Online Comment

Application H06-0073-22
Location OLD SCHOOL HOUSE CHURCH STREET GEDNEY DAWSMERE PE12 9NL
Proposal Conversion of outbuilding into additional living accommodation including link extension

Name Greg Watkinson
Address Conservation Officer

KINGSPAN INSULATED STANDING SEAM ROOFING  
N.T.S.

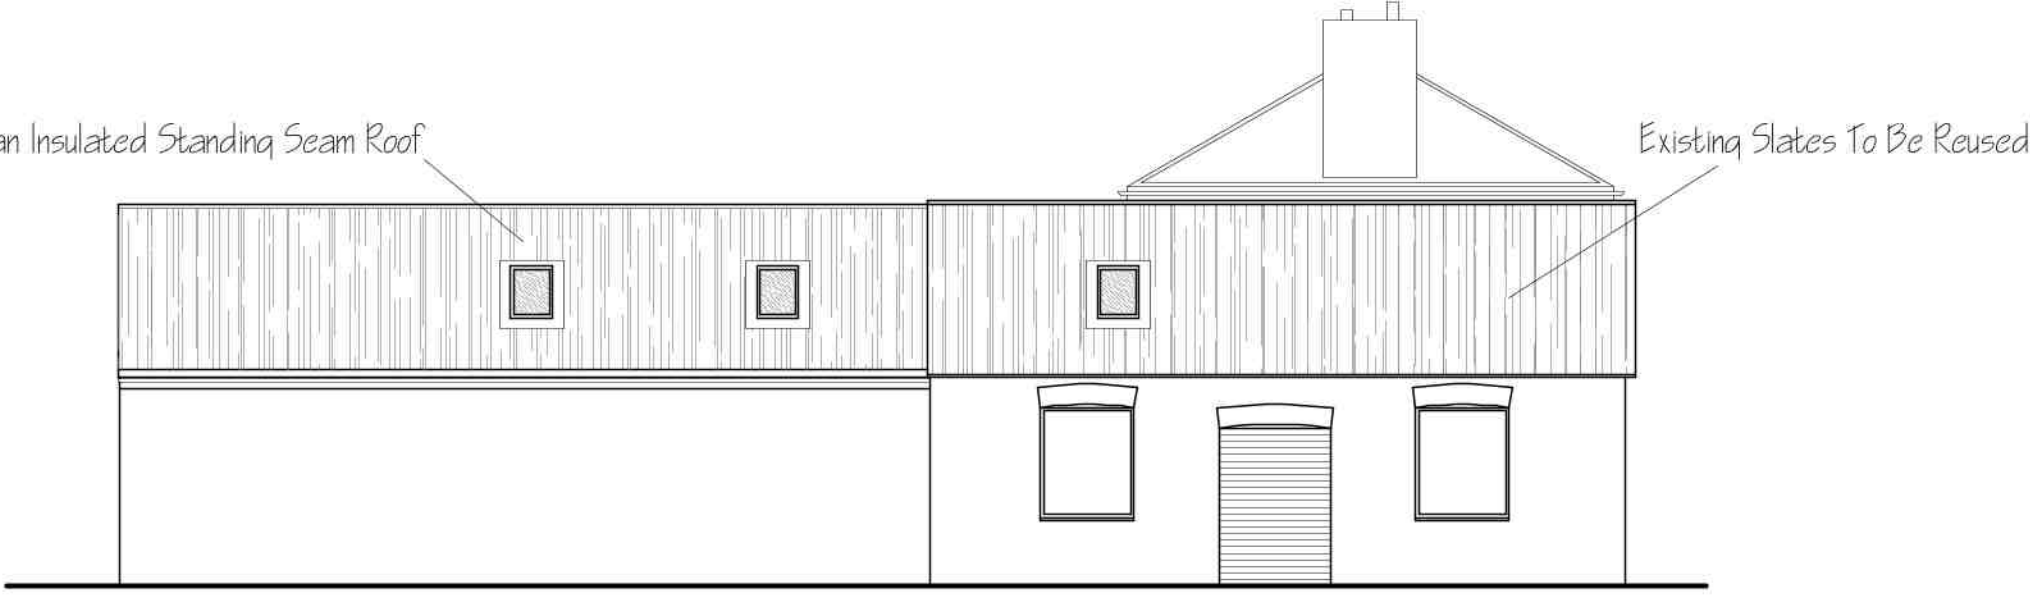
However, whilst I have no issue with the principle of raising the roof level of the outbuilding or adding roof lights, I do question the proposed usage of modern, metal roofing panels and would recommend that to encourage accordance with Policy 29, Section B, Para 4 of the SELLP, the applicant should be encouraged to retain slate as the roofing material for the outbuilding. Slate is the historic standard for properties in Dawesmere. As this site is one of the few remaining properties that have retained that material, as a prominent, historic property, I would suggest that retention of such materials are important to the preservation of local distinctiveness in this conservation area, which is considered currently to be 'at risk'. I would therefore suggest that the proposal should be amended to reflect this or the applicant should provide further, reasoned justification as to why the slate roof must be replaced with the desired material.

GROUND FLOOR PLAN

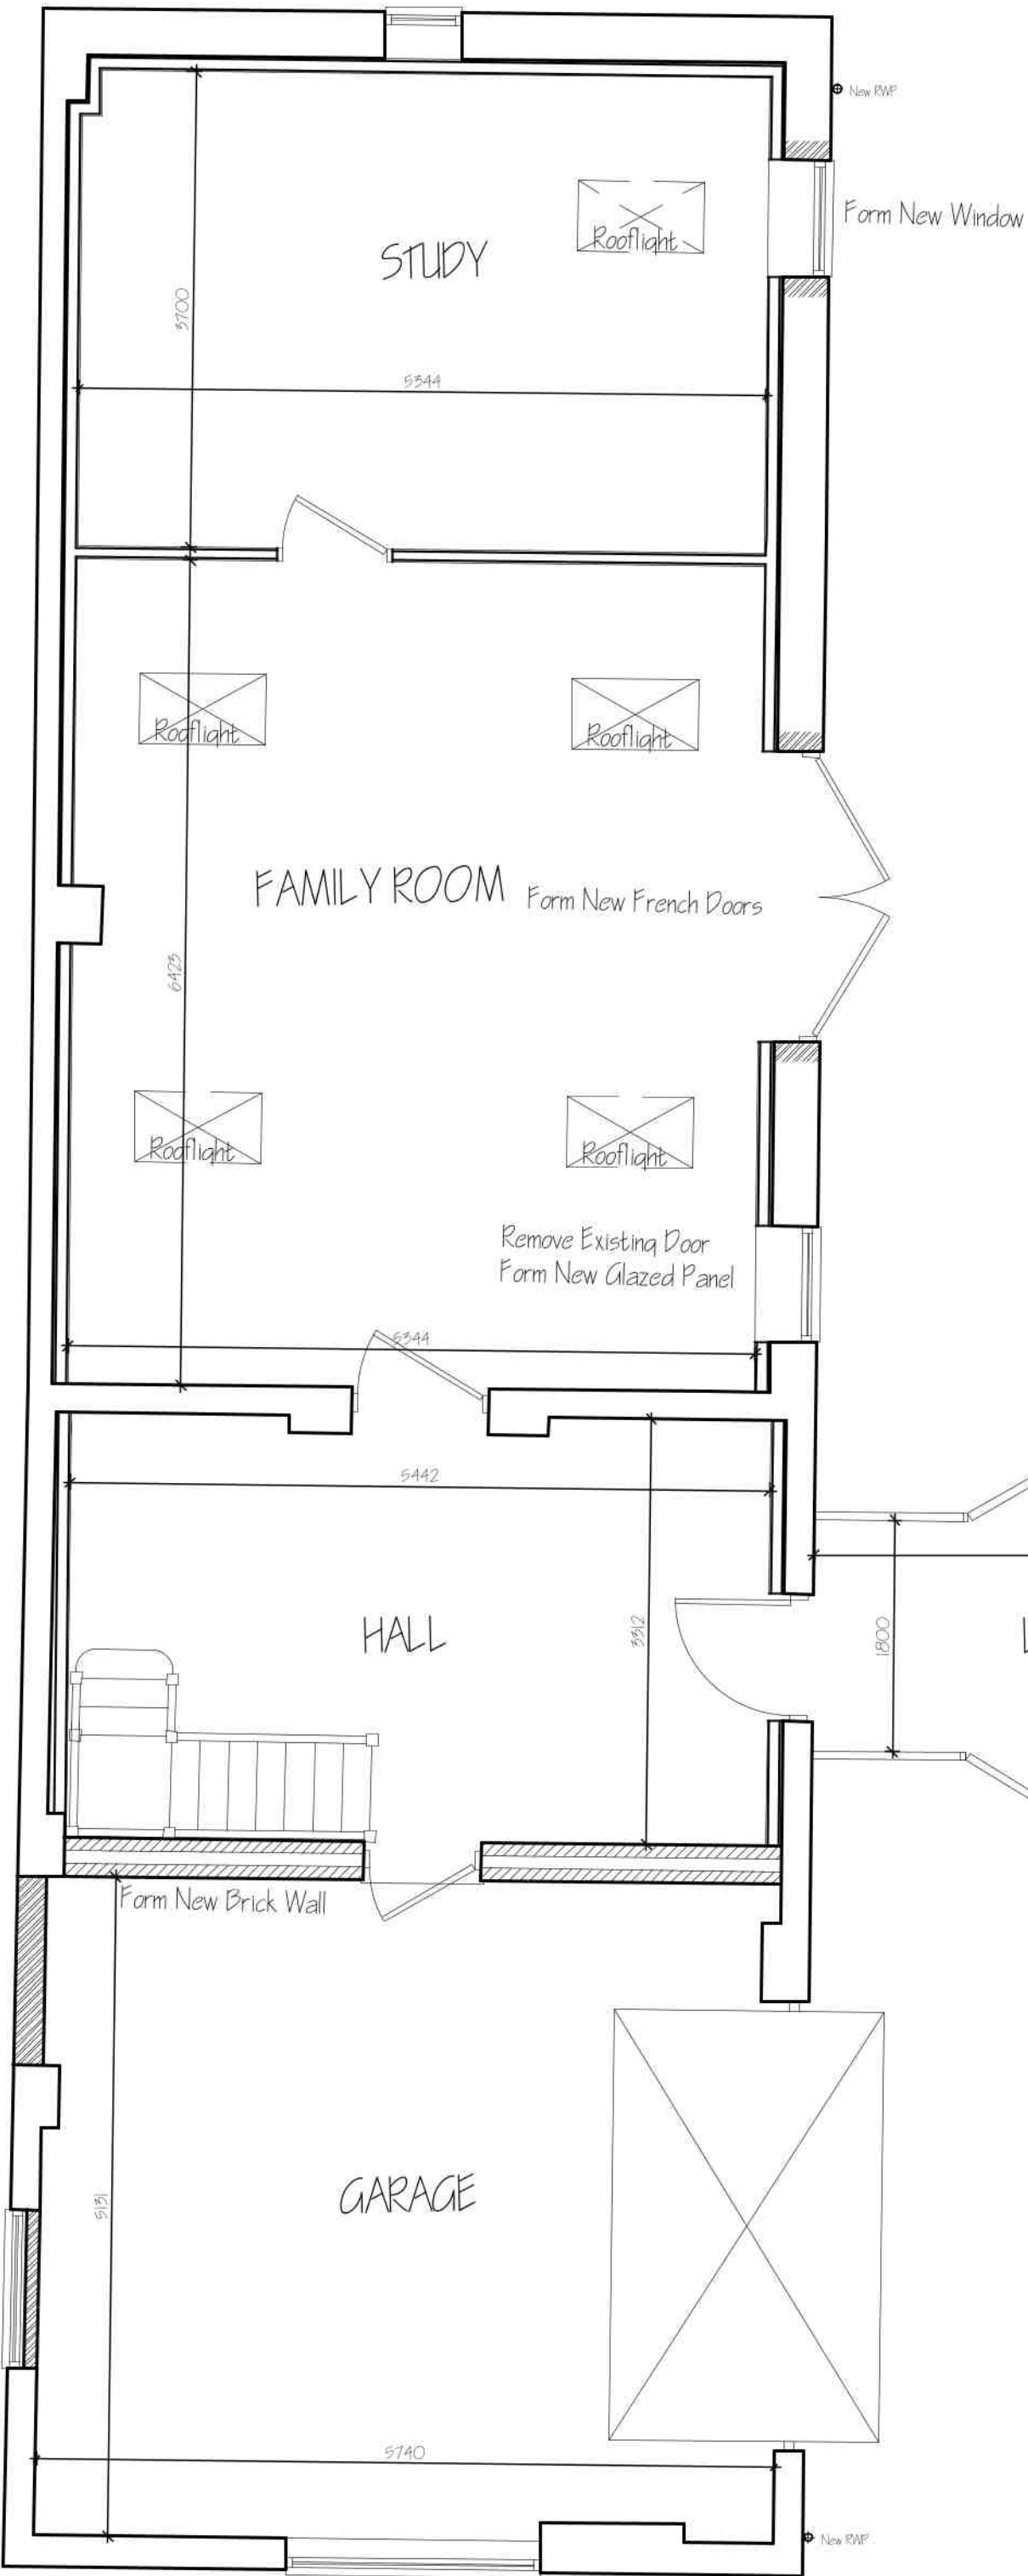
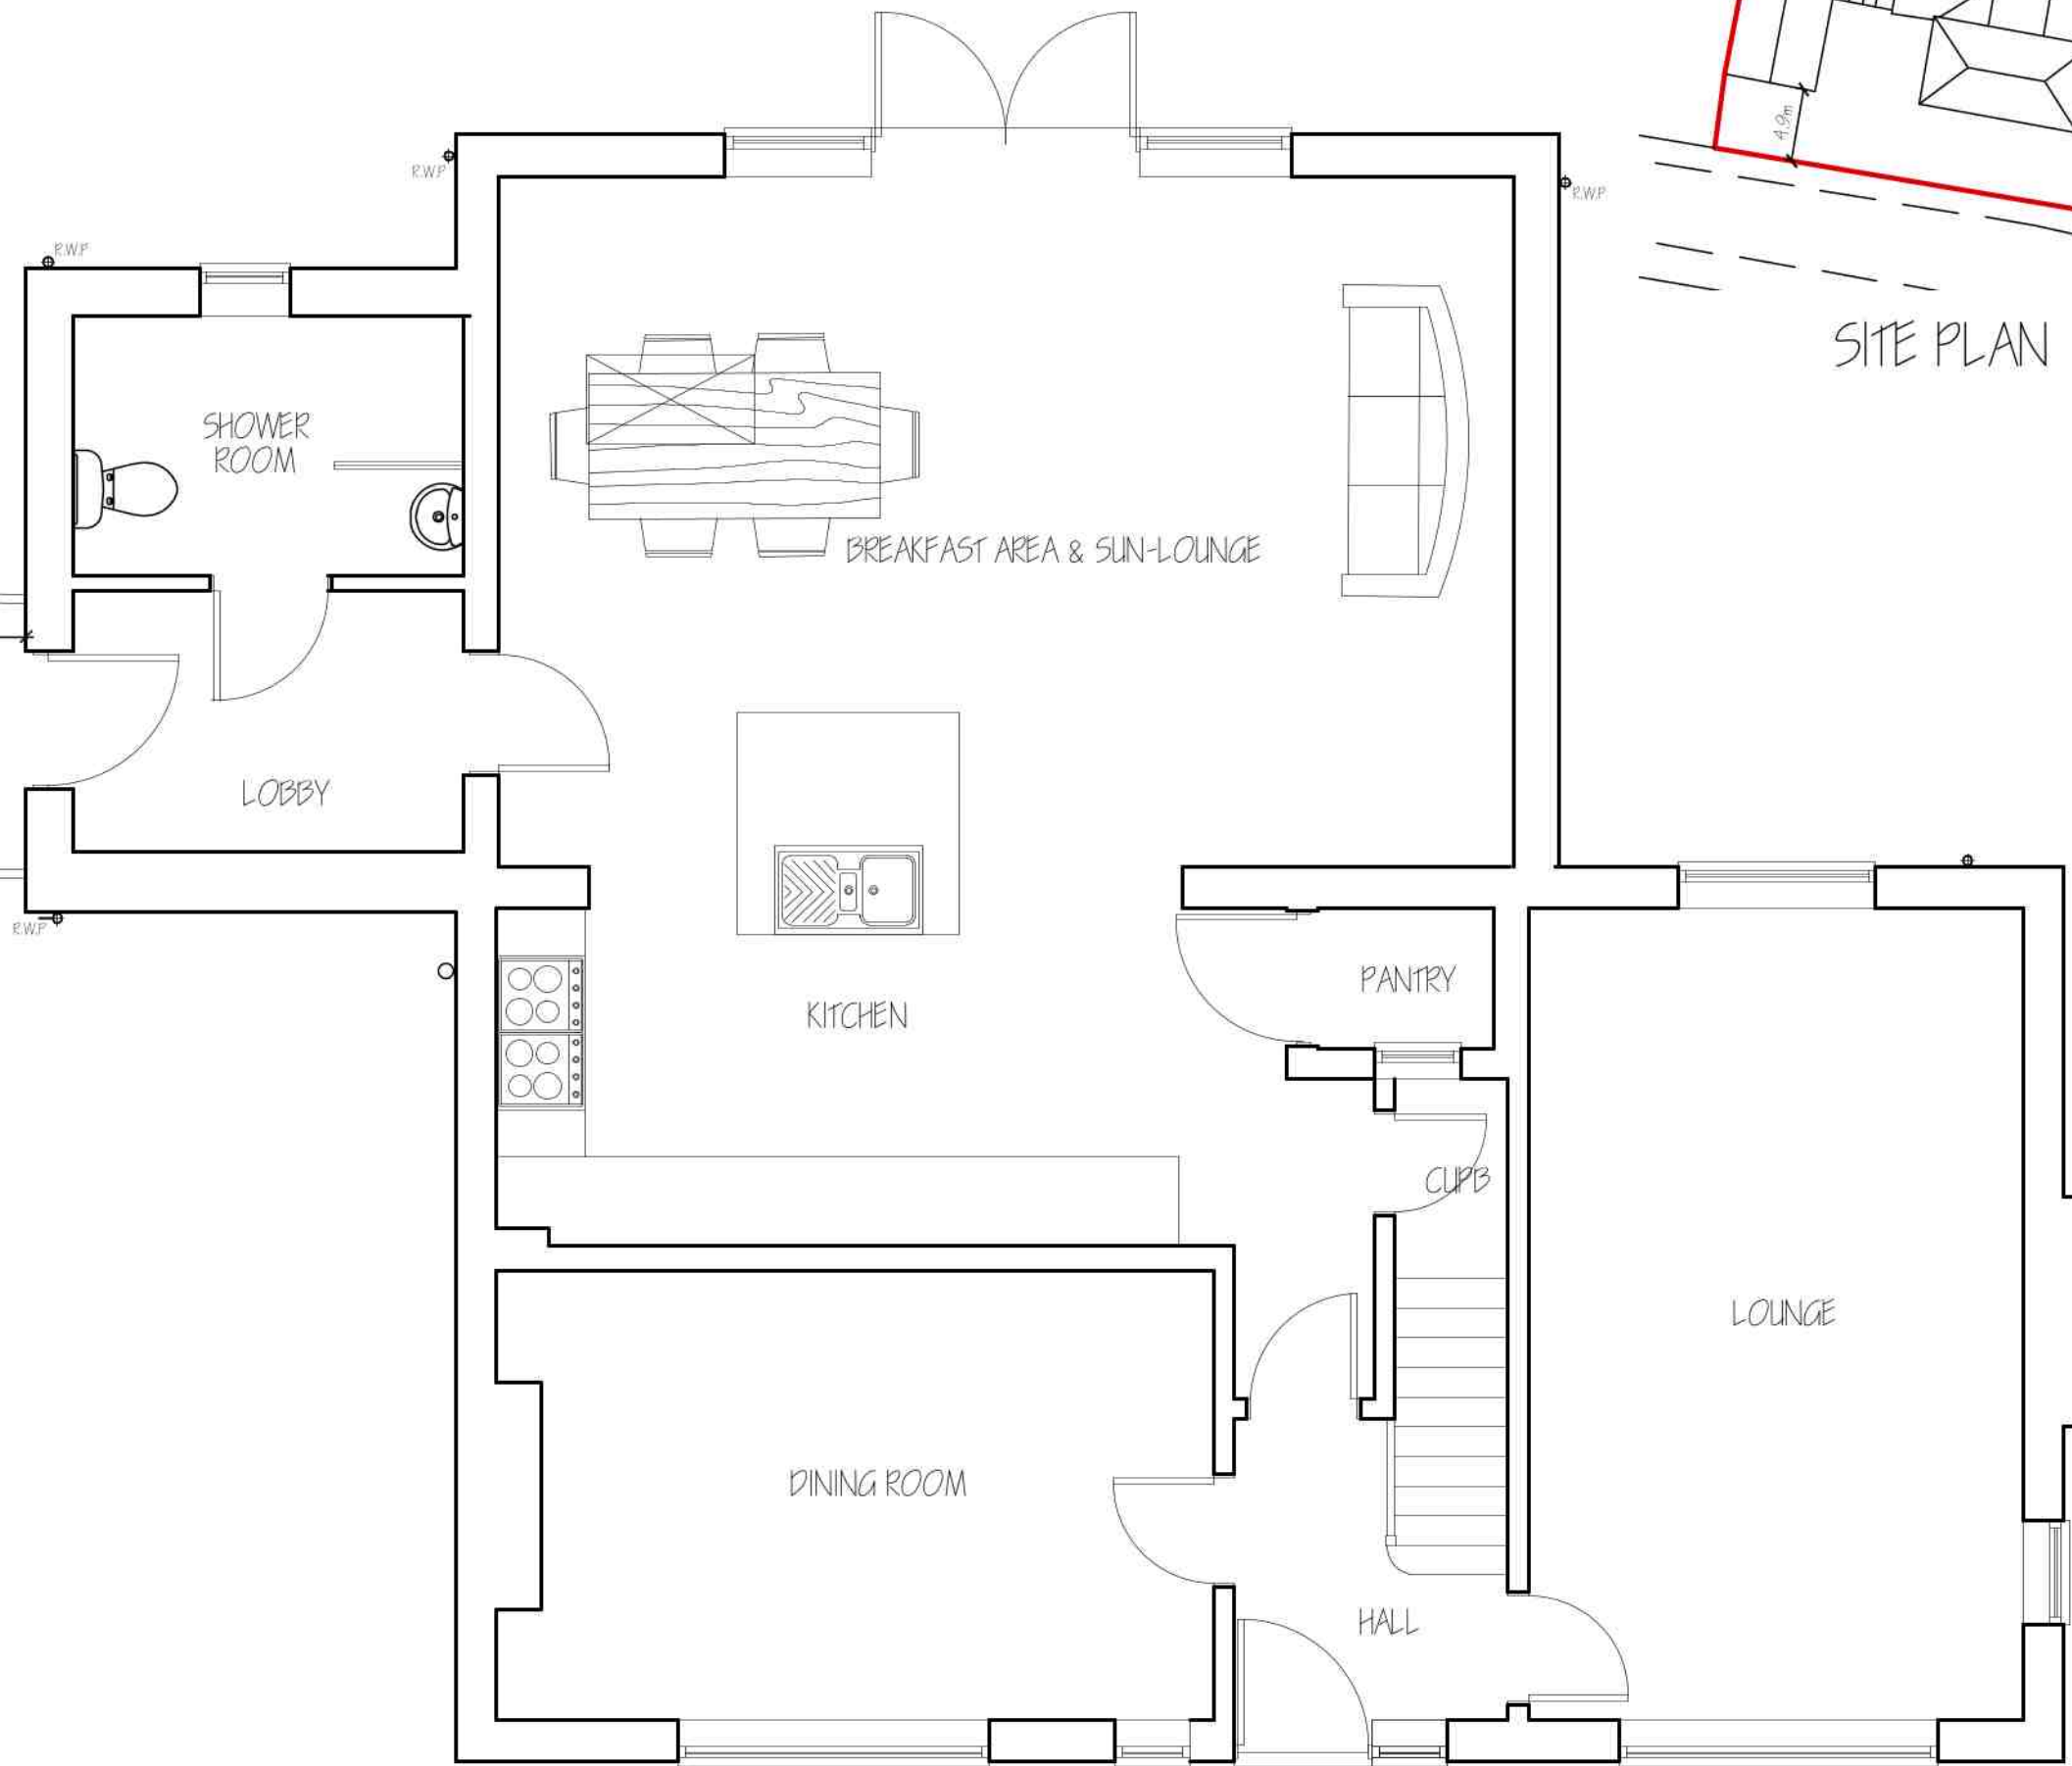
Finally, I would suggest that we would need further information relating to the materials to be used in the glazed link. No information appears to have been provided as to what material the frame of this link will be constructed of. I assume this means it would be UPVC in line with the windows, but this needs clarifying.
